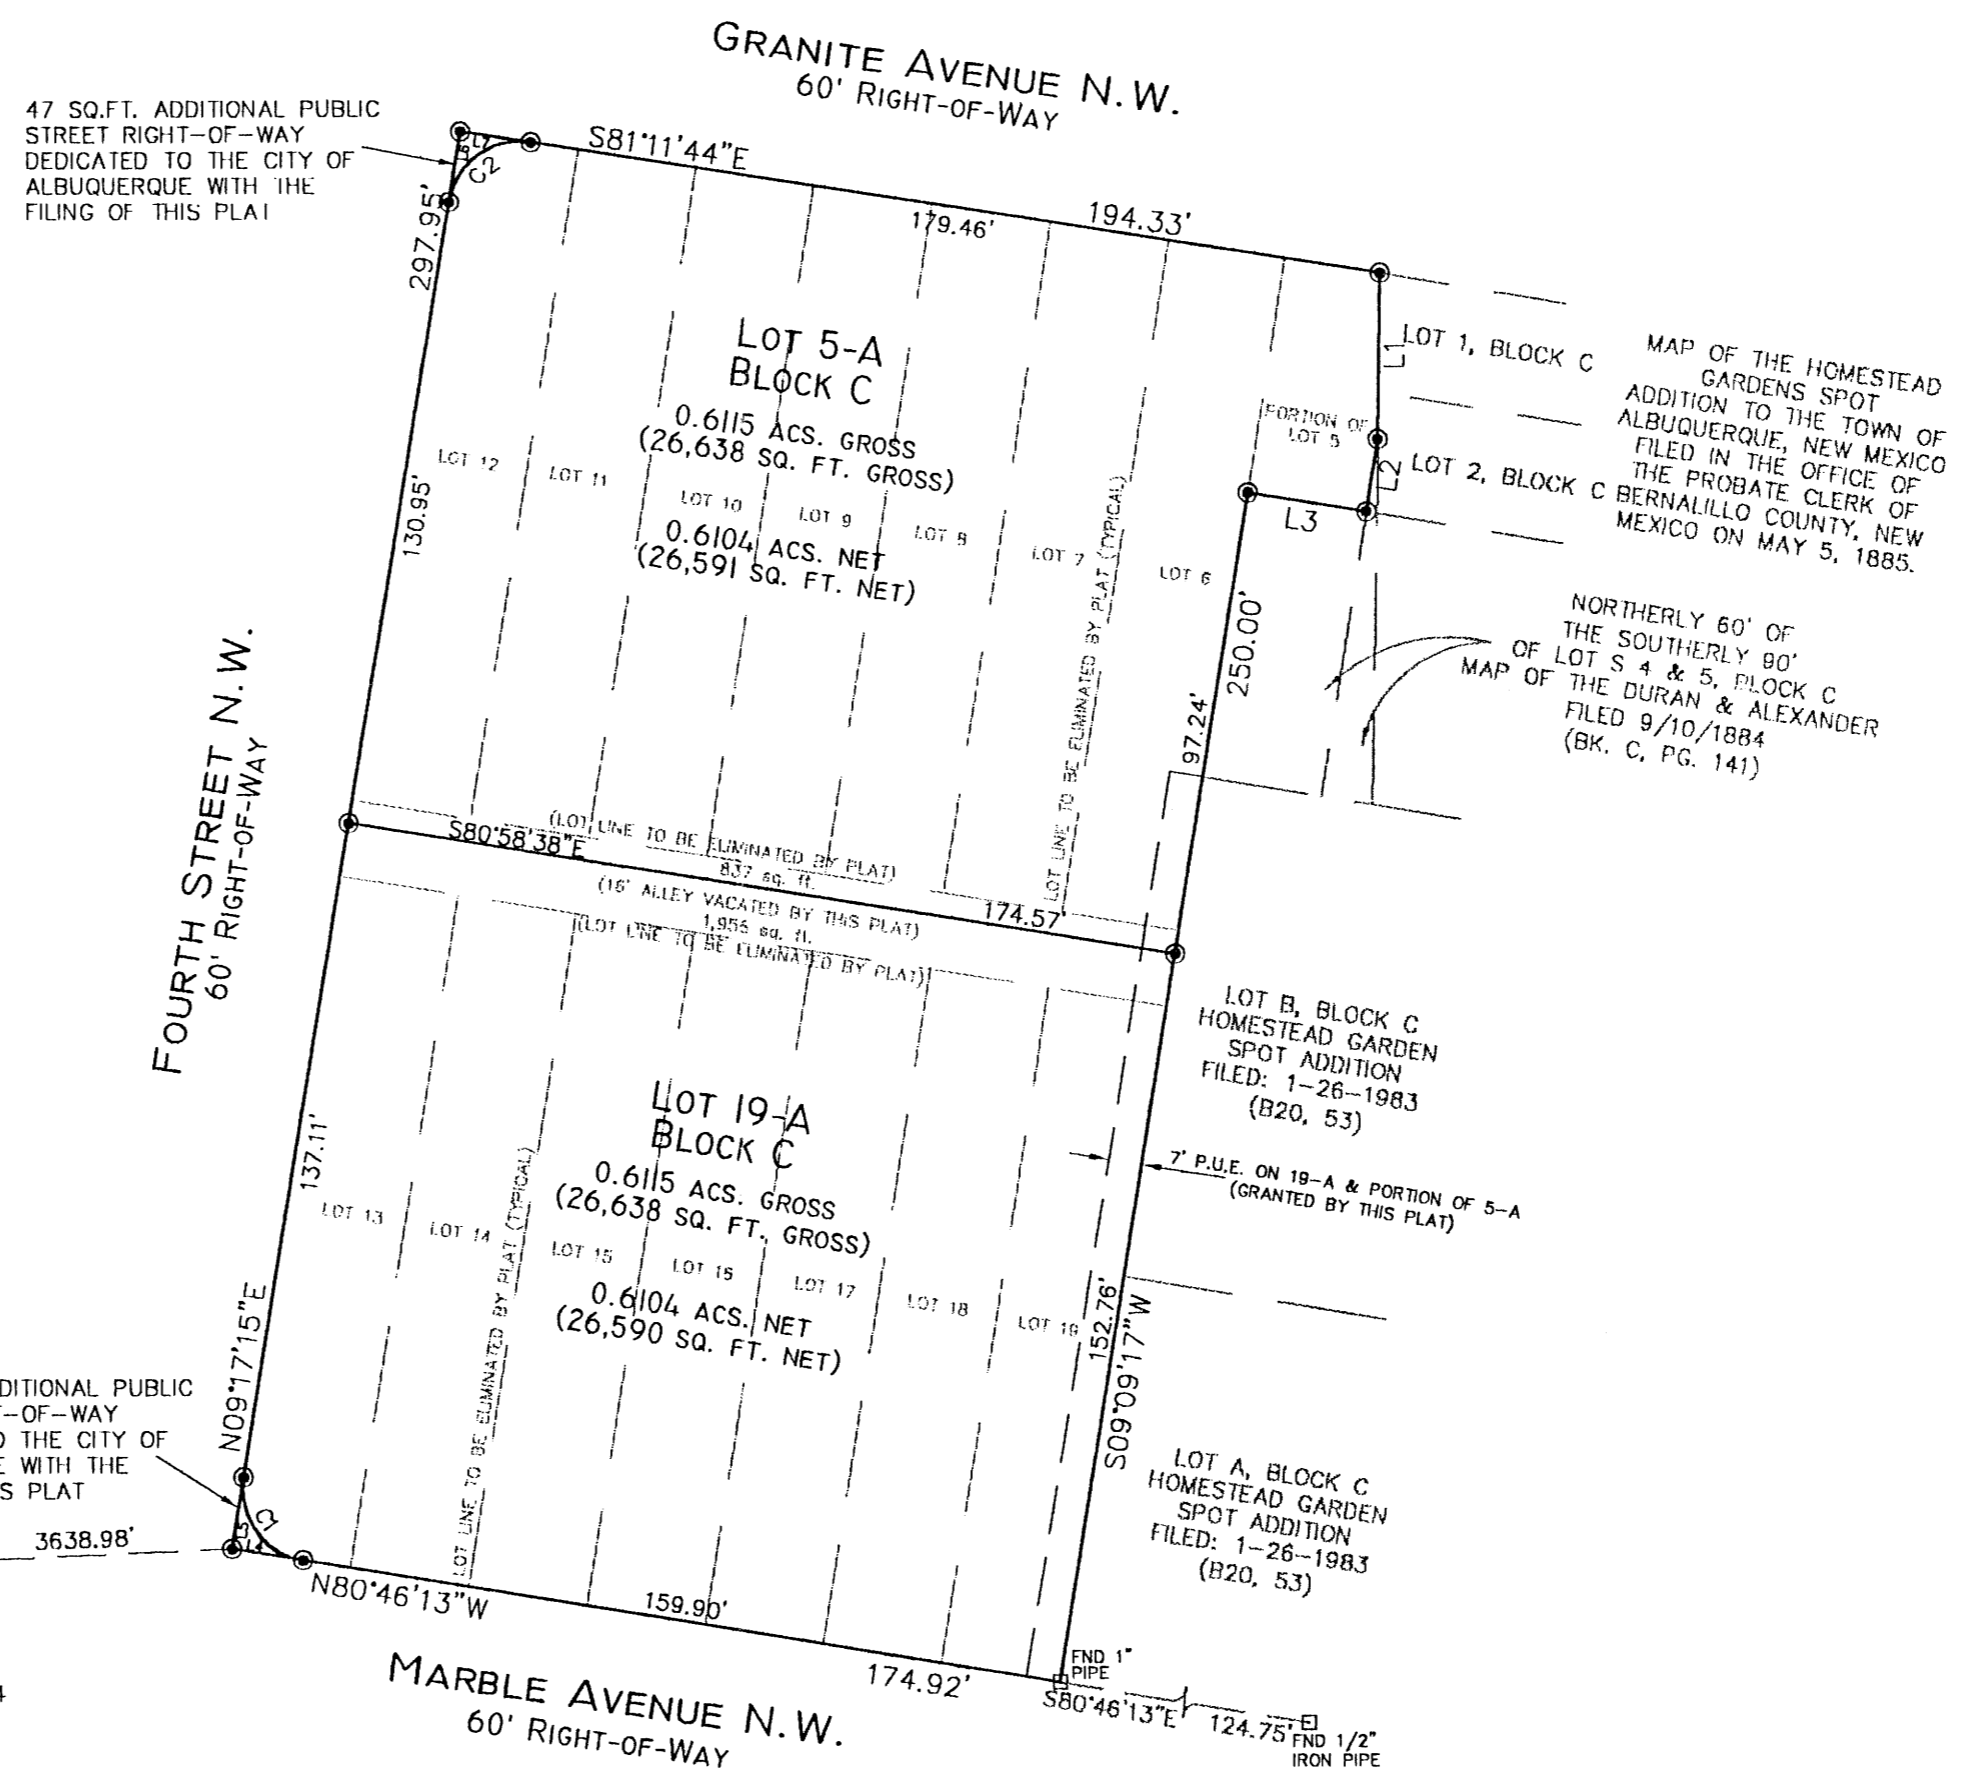
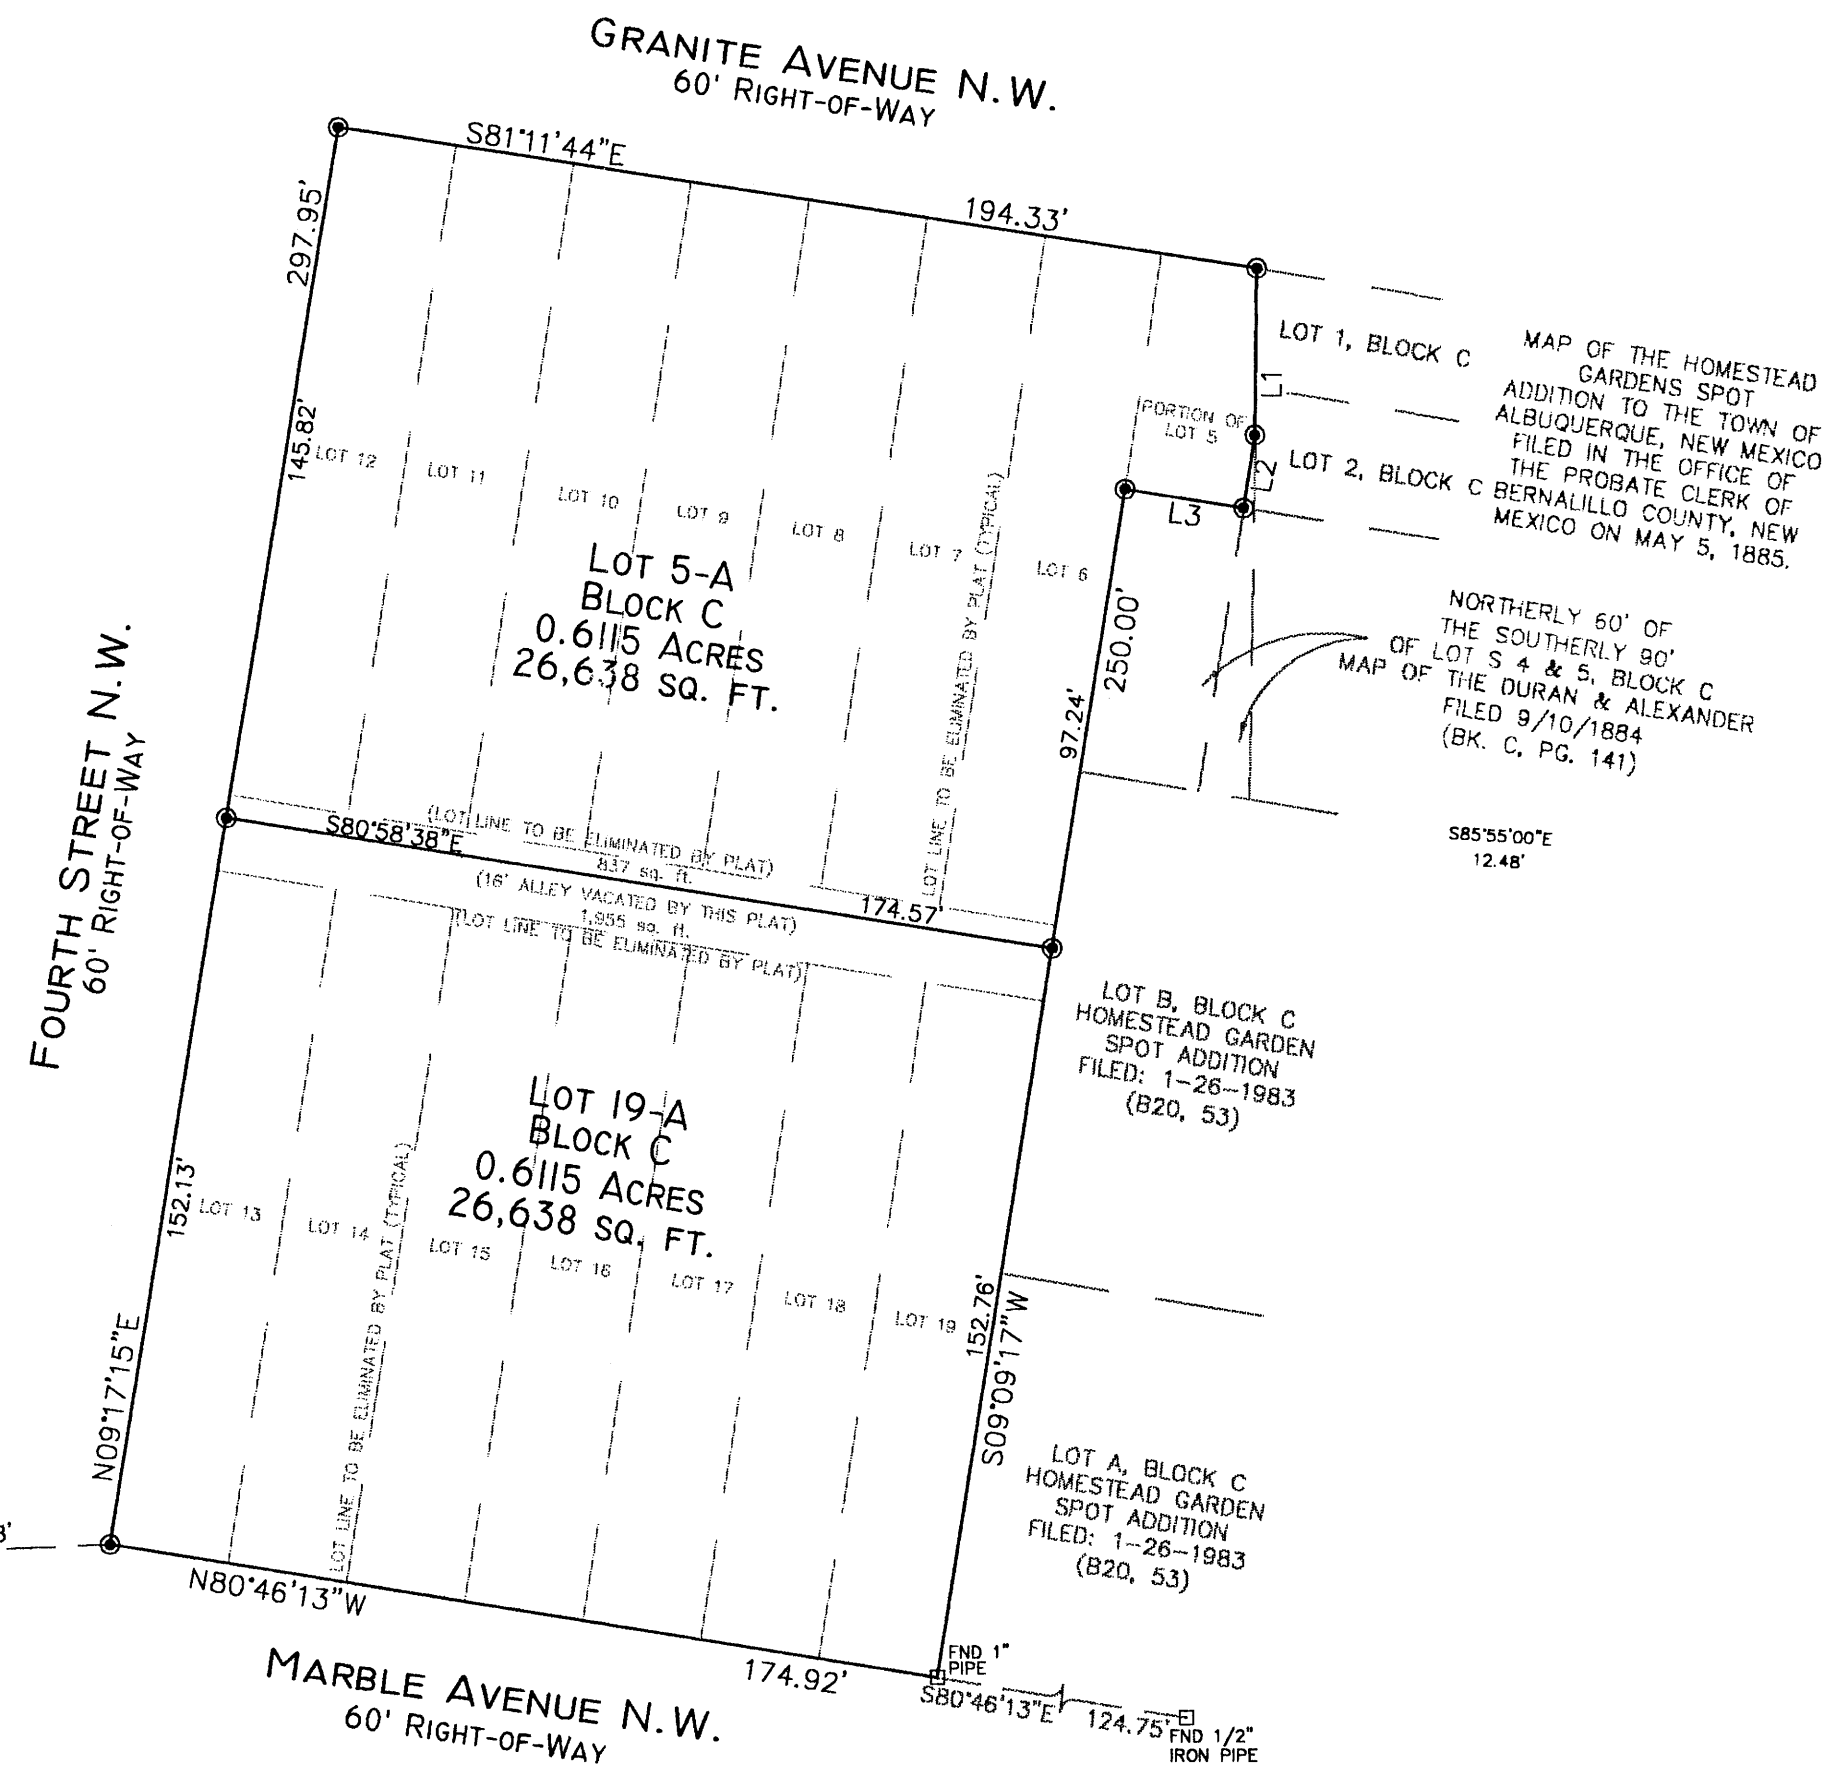
No objection to the vacation request. A sketch of the existing improvements are needed to determine infrastructure requirements. Where are the radii dedications?

Did all property owners who are adjacent to the section of the alley proposed for vacating sign the plat? Planning defers to Transportation on the issue of the alley vacation. Why is the proposed new lot line not in the center of the proposed vacated alley section? The solar collector prohibition language is missing from the plat.
